# West Burton Solar Project

## Environmental Statement Addendum: Chapter 10: Hydrology, Flood Risk and Drainage

PINS reference: EN010132  
Document reference: EX1/WB8.4.10.1  
APFP Regulation 5(2)(a)

Figure 4.1: Illustrative Site Layout Plan West Burton 1

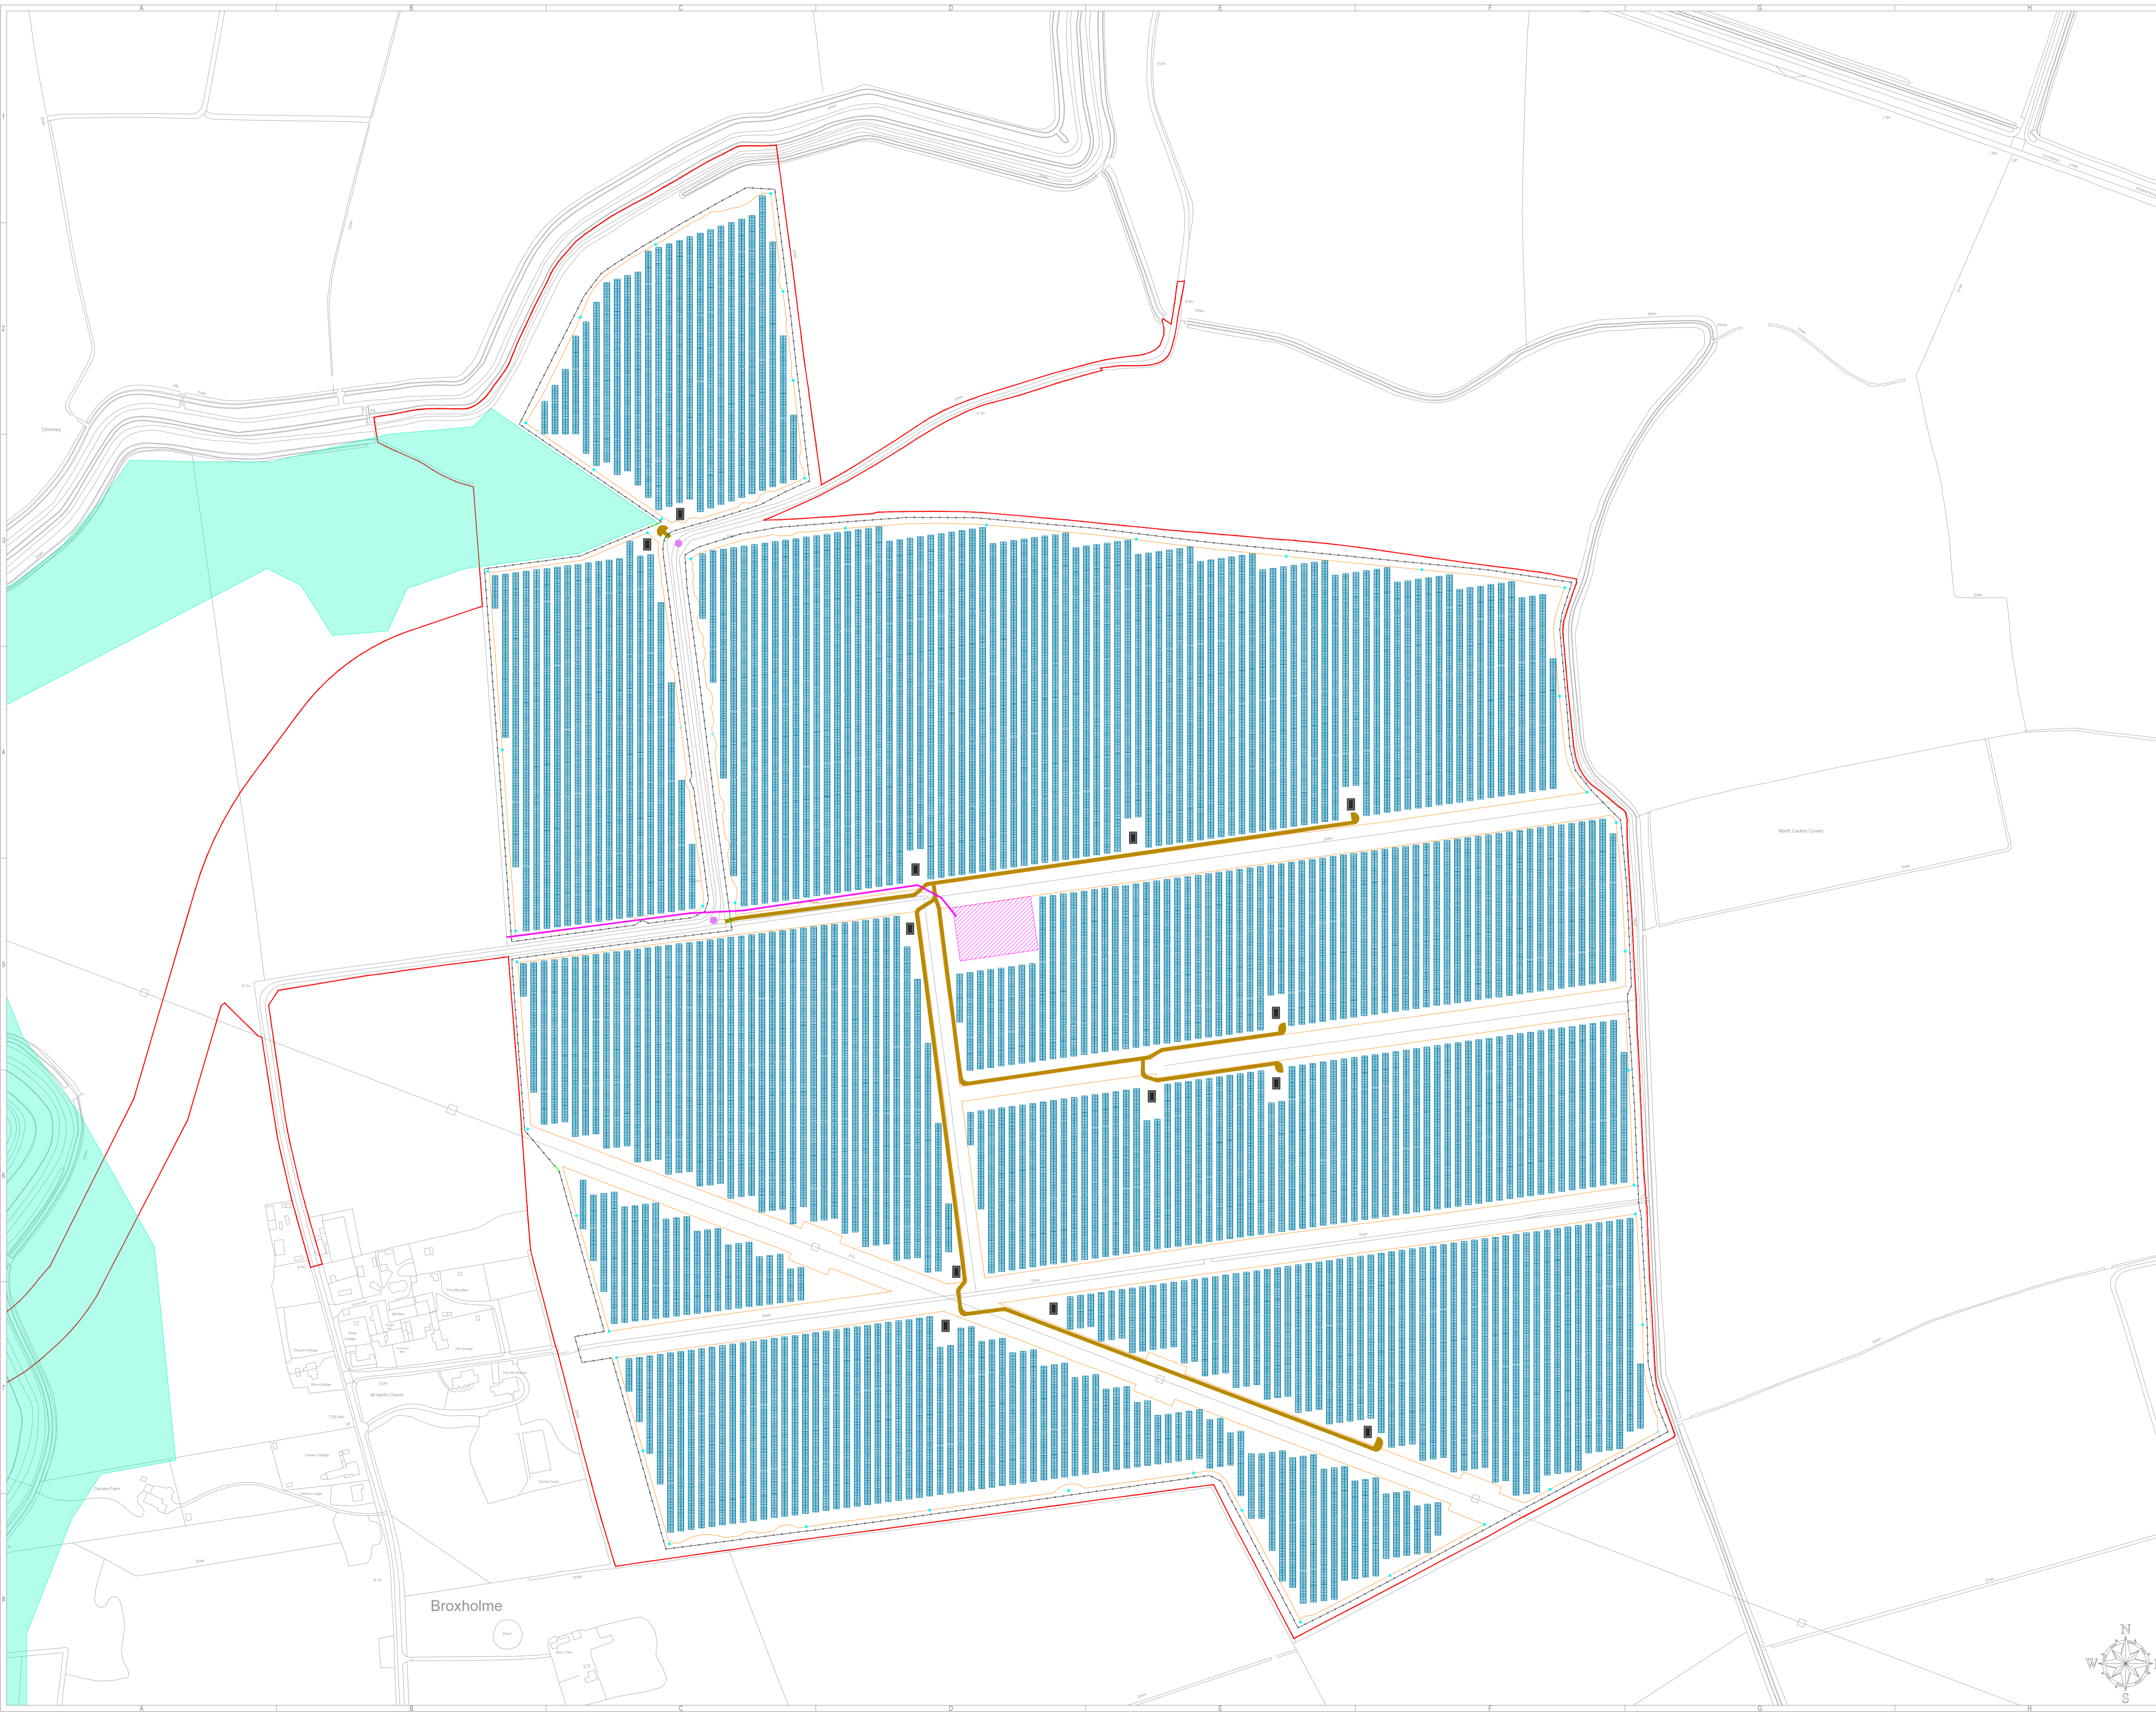
3.2.1 Annex D - Illustrative Layout Plan at page 24 of **6.3.10.3 Environmental Statement - Appendix 10.3 Flood Risk Assessment and Drainage Strategy for West Burton 1 [APP-091]** is to be updated to show the extent of the River Till Flood Storage Area and the area of the Order Limits that falls within the area. The updated plan is shown at Appendix A below. This is the same as the revised plan **WB6.4.4.1\_A ES Figure 4.1 - Illustrative Site Layout Plan West Burton 1 Revision A [EN010132/EX1/WB6.4.4.1\_A]** as submitted at Deadline 1.
